From:
Sent: 11 March 2024 14:04
To: DCAdmin
Subject:

Planning Application no 2023/93576
Land to the East of Robledo, Beaumont Park Road HD4 5JT

Appendix 3: Proposed Development Plan

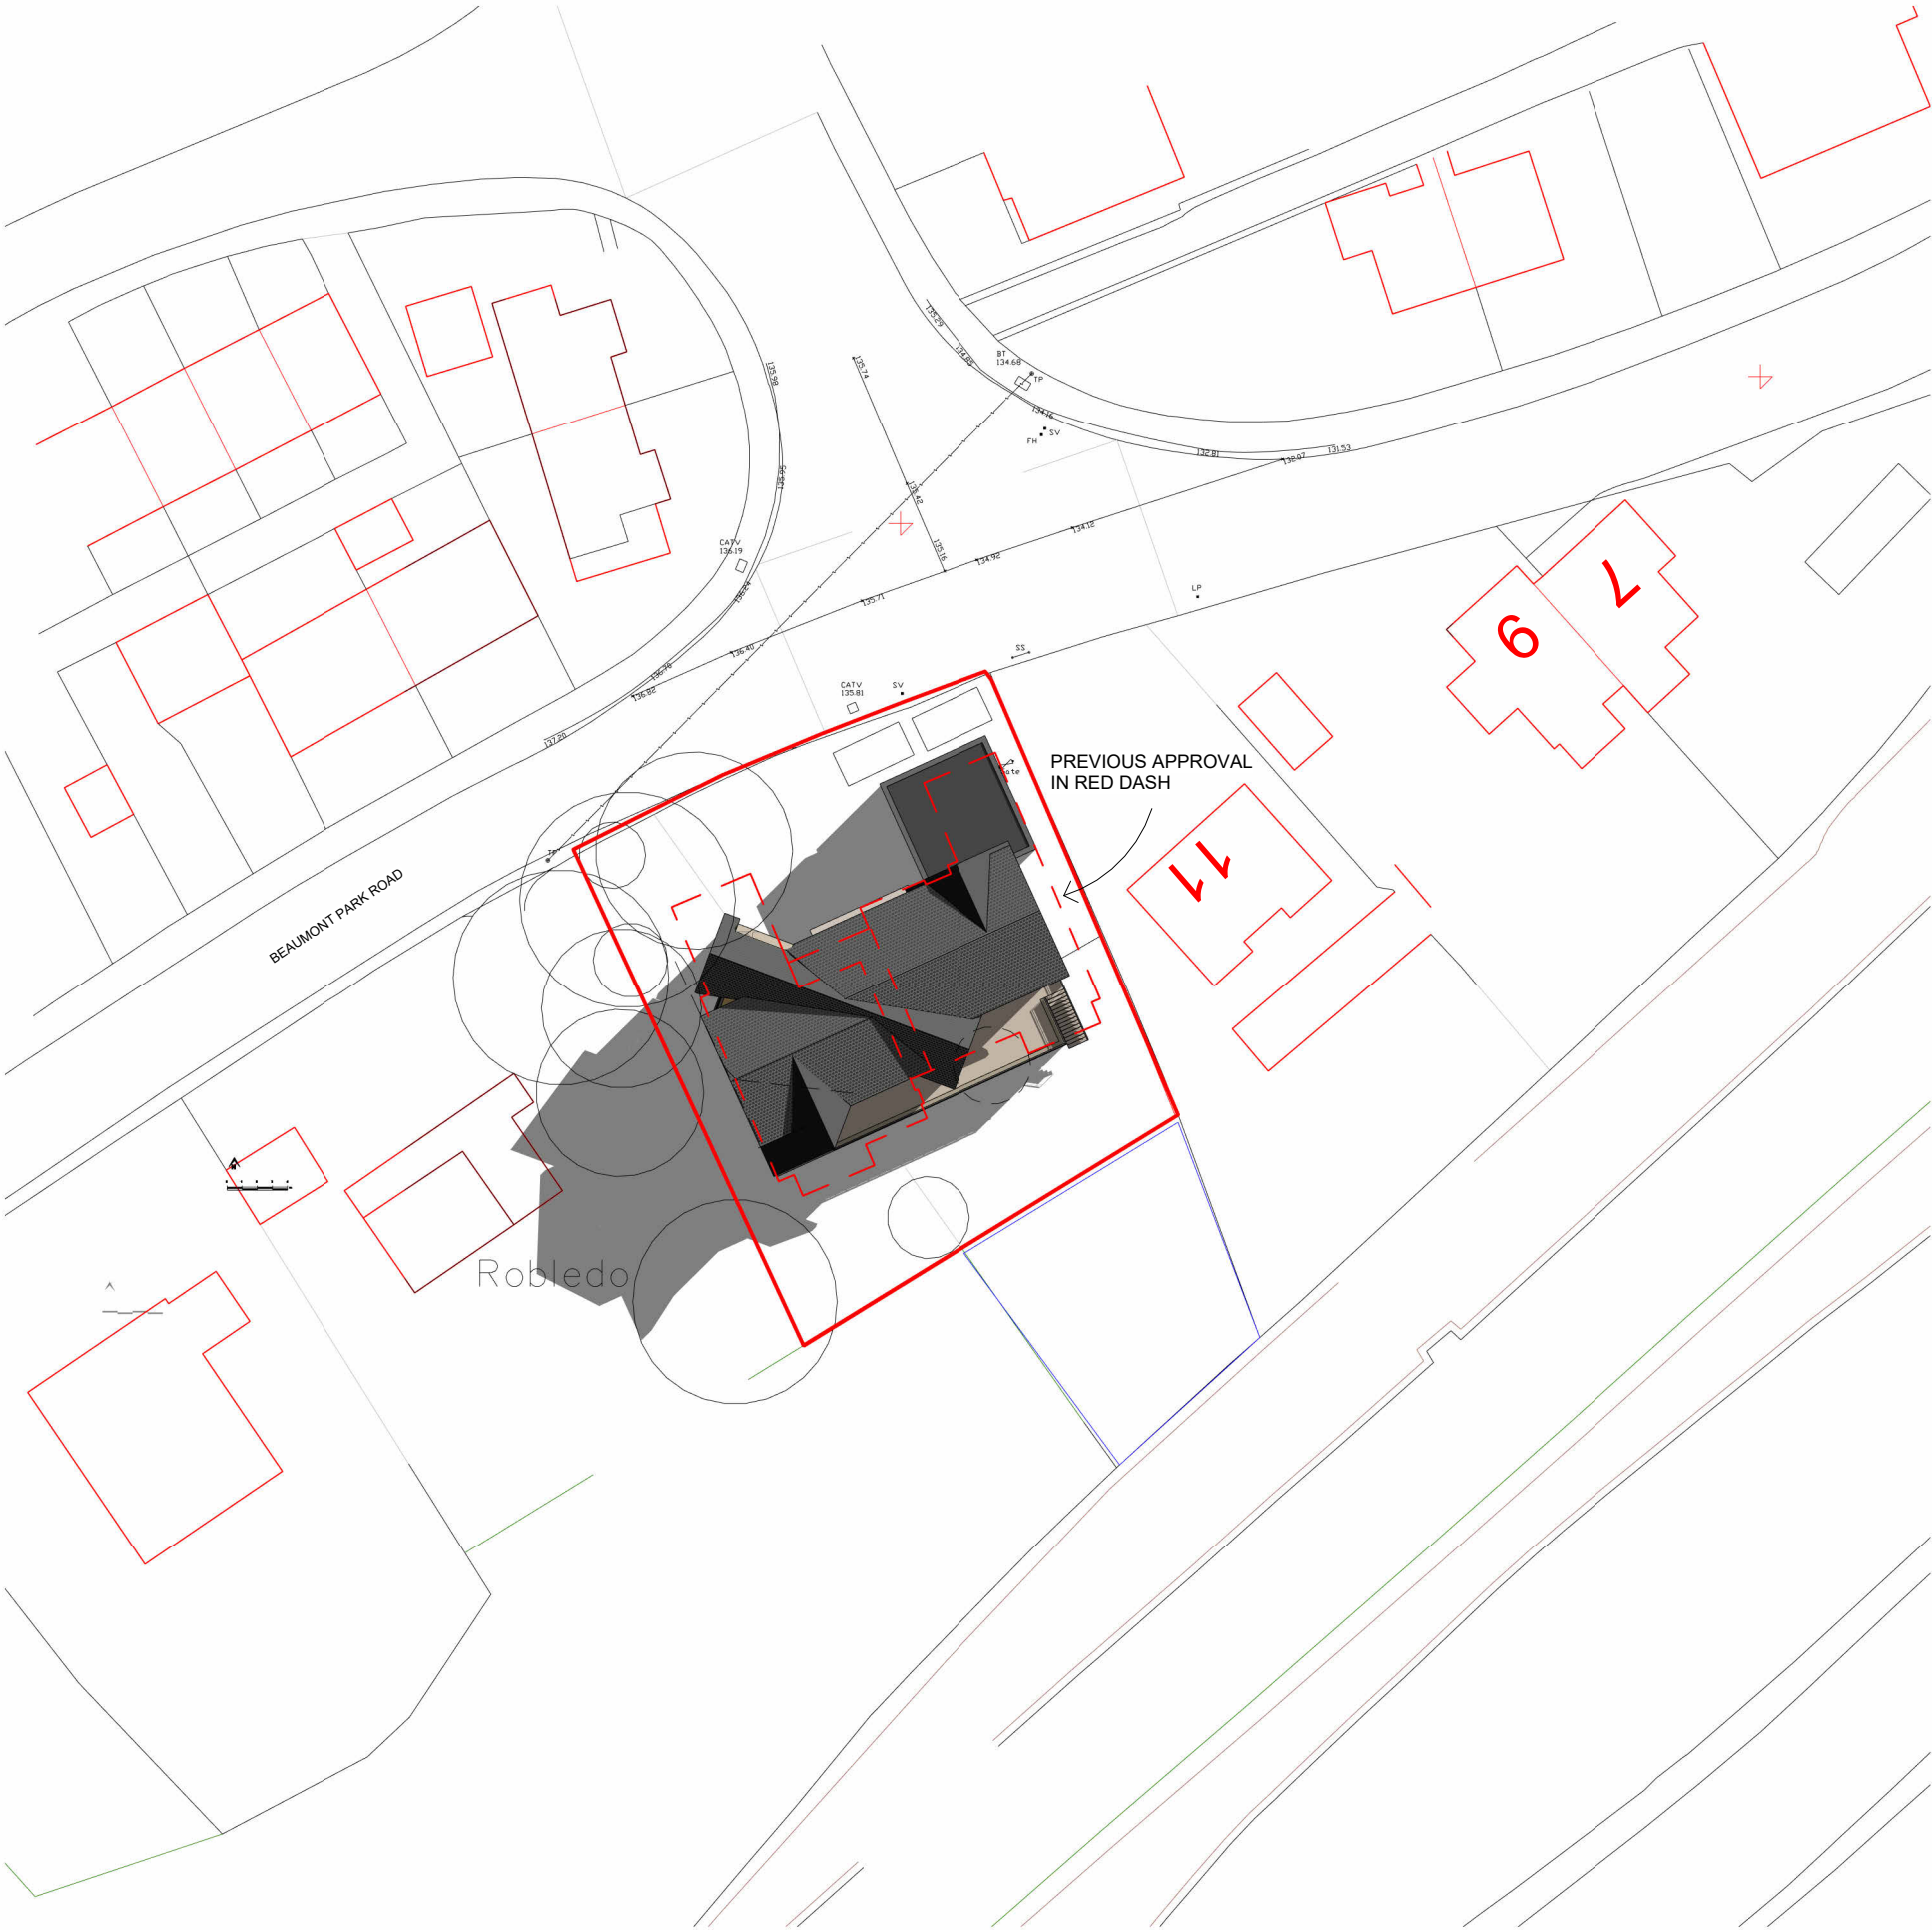
My comment is - I spoke to Mr Bains earlier this year when he visited the site. I told him that some of the trees had preservation orders on them. He said he was unaware of that.

I think looking at the plans these trees have not been taken into account when the plans were drawn up.

A survey was done re the plot for flora/fauna etc. Please ask that the preserved trees have been taken into account.

This is important or the first thing which will happen is they are cut down if a mistake has been made.
